Response to Submissions Report

State Significant Development – SSD 9483

Chatswood Public School and Chatswood High School

5 & 24 Centennial Avenue, Chatswood

drawing	
Building G - Elevations	
scale	1 : 250@A1
drawn	LDC
checked	LDC
project no	180326.00
drawing no. DA-BG-A2002	
issue	
C

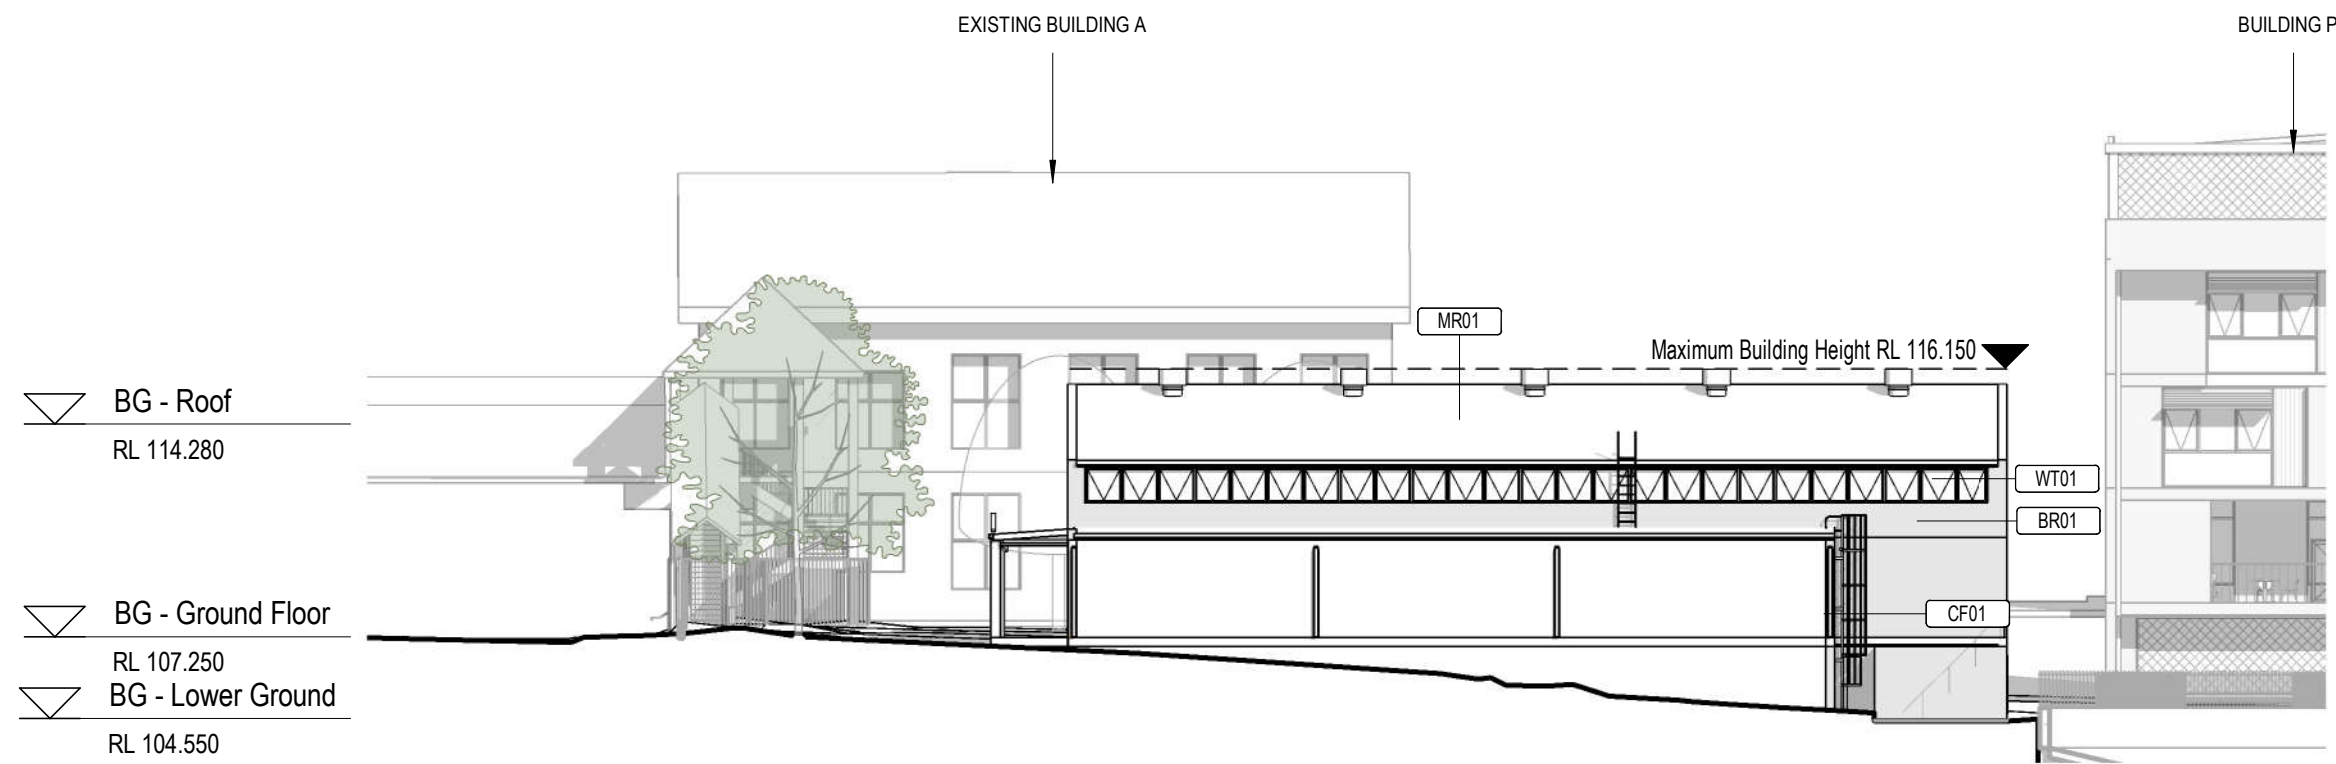
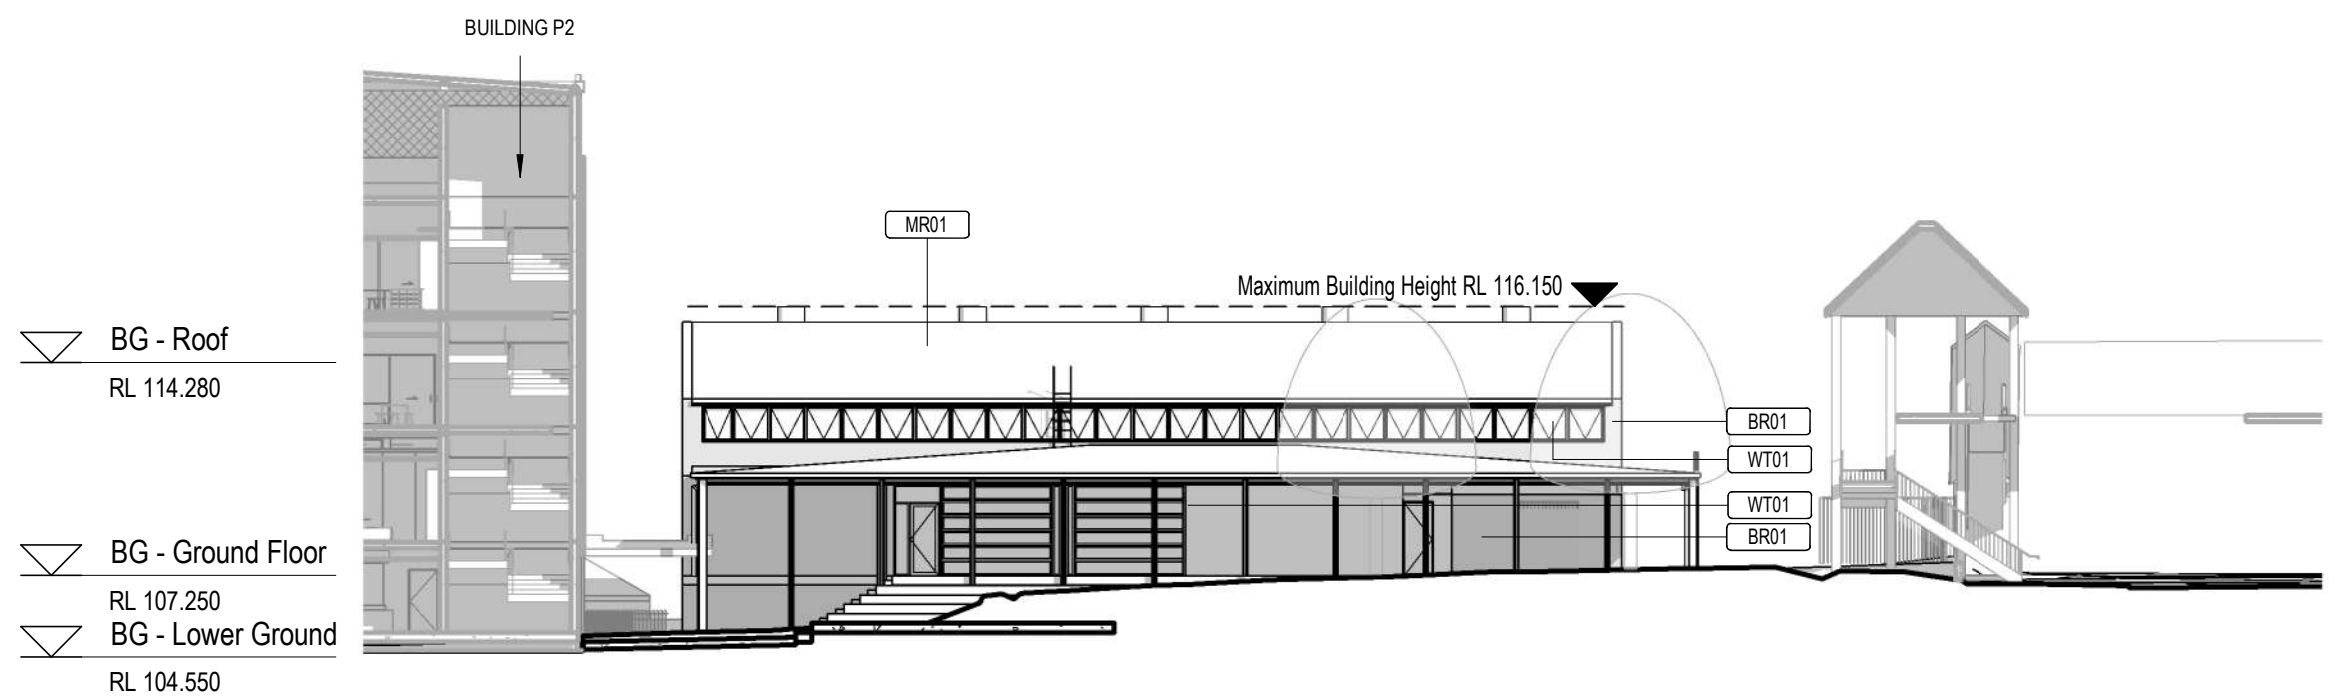
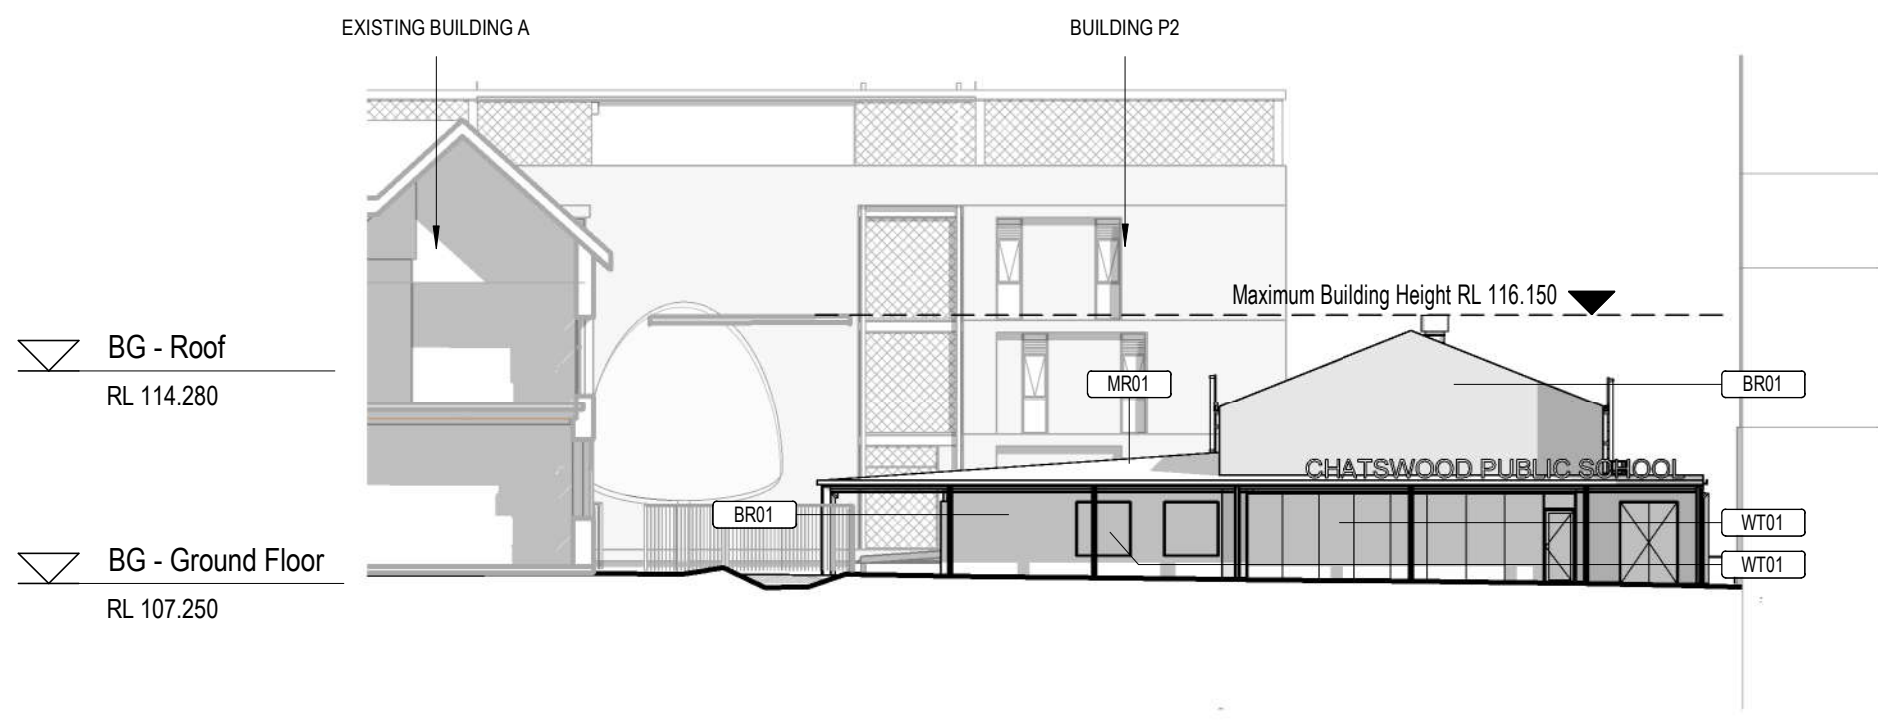
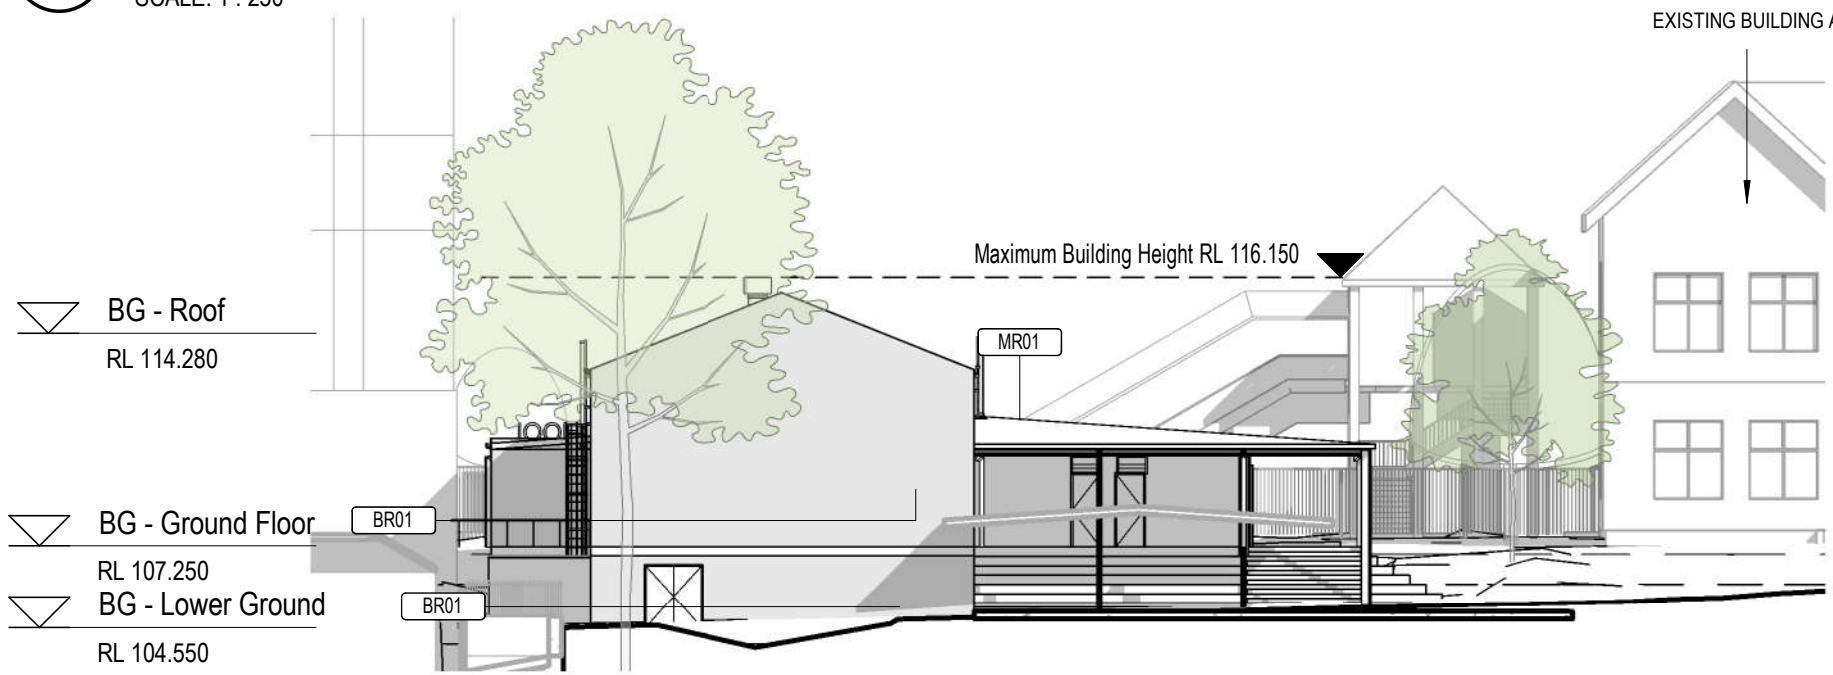
Building G – Chatswood Public School site Concerns that the setback is inadequate and concerns about the adjoining retaining wall along the boundary with 2 James Street.	The design has been adjusted to increase the setback of Building G from the northern boundary, and to also reallocate rooms to increase building separation to the adjoining neighbour.	See Cover Letter Attachment 2 Attachment 8

The existing retaining wall was reviewed by the Structural Engineer and was found to be structurally sound. Further investigations will take place during the preliminary construction phase. The Engineer confirms that all foundation works will be to rock below the building and will not result in any additional surcharge pressure onto the rear face of the existing retaining walls.	Attachment 9 Attachment 11
Building K – Chatswood High School Concern that design does not make the most of the available space, could fit an additional two storeys under the columns.	There is not enough compliant head height to create a two-storey space for the outdoor workshop.	Attachment 2
Building T – Chatswood High School Concerns raised about bulk and scale and blank wall along western frontage	The height of Building T is lower than the existing buildings in that location. The materiality of the western facade of Building T consists of brick to the “plinth” at lower ground, with pre-finished fibre-cement (FC) sheeting above in a panelled arrangement to break down the length of façade on the western elevation. High-level acoustic louvres will enable cross ventilation. The hinged double doors on the western façade are emergency exits and will not be used for general circulation or entry to the hall. With regard to visual privacy, there is minimal glazing on the western façade and the dense biodiversity corridor between Building T and the western boundary will be maintained.	Attachment 2
